Harnett County Government Complex
307 Cornelius Harnett Boulevard
Lillington, NC 27546

Re: Status of Improvement Permit Application #09-5-22992

**SURVEY FOR:**  
**PROPOSED PLOT PLAN - LOT - 70**  
**ASHEFORD SUBDIVISION**

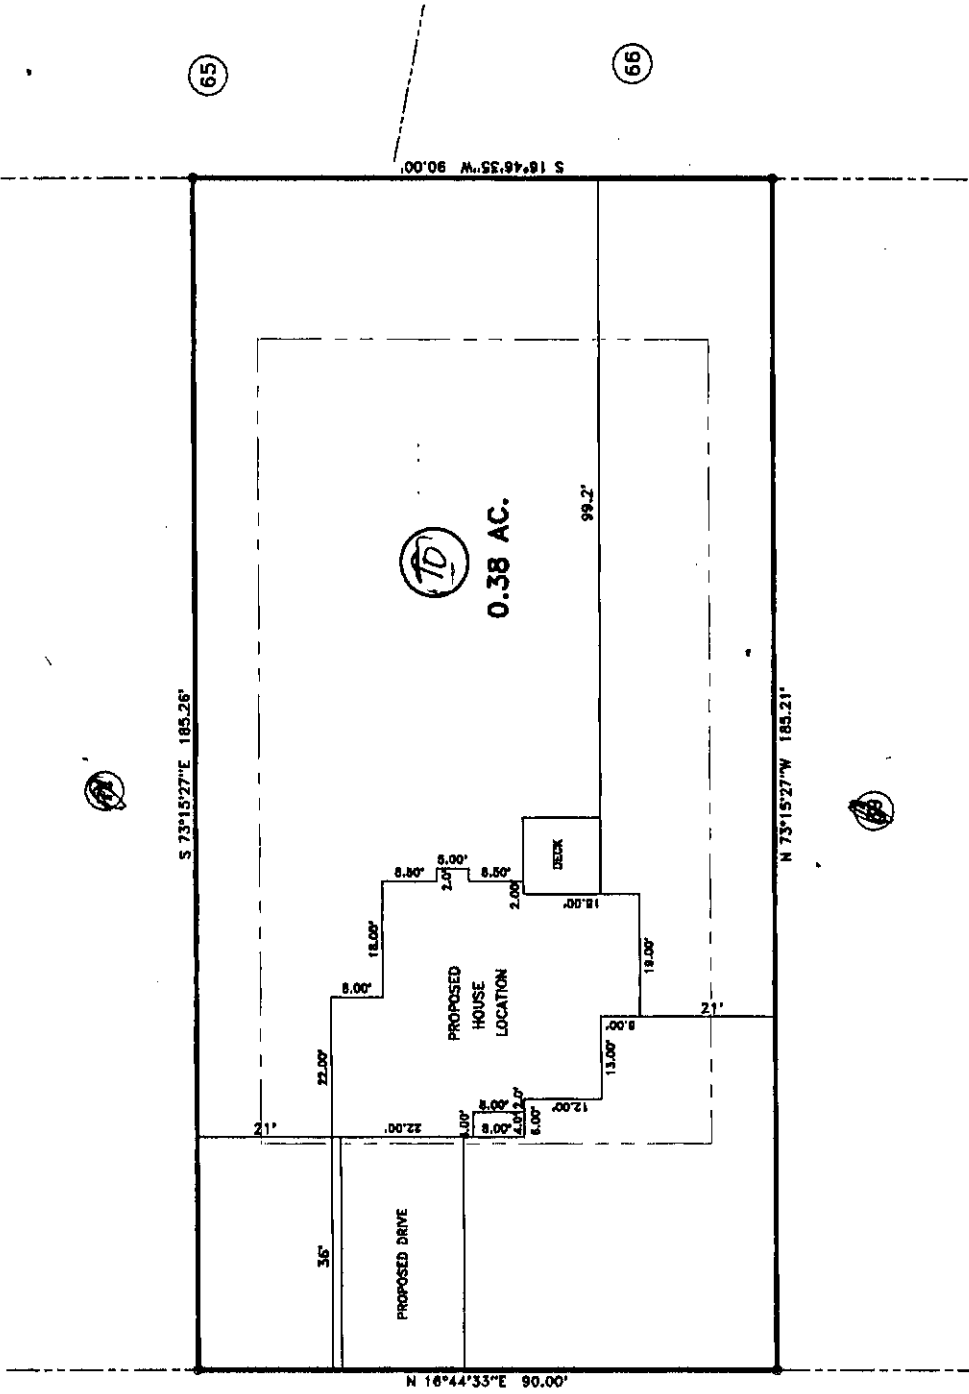
- 1. Property lines/corners not marked or labeled**
Need left side irons located. Due to limited useable soil this is vital to verify setbacks.
(\$25.00 fee incurred)
- 2. House corners not marked or labeled *(\$25.00 fee incurred)*
- 3. Directions not clear to property *(\$25.00 fee incurred)*
- 4. Property needs brush or vegetation removed
- 5. Backhoe pits required
- 6. Other
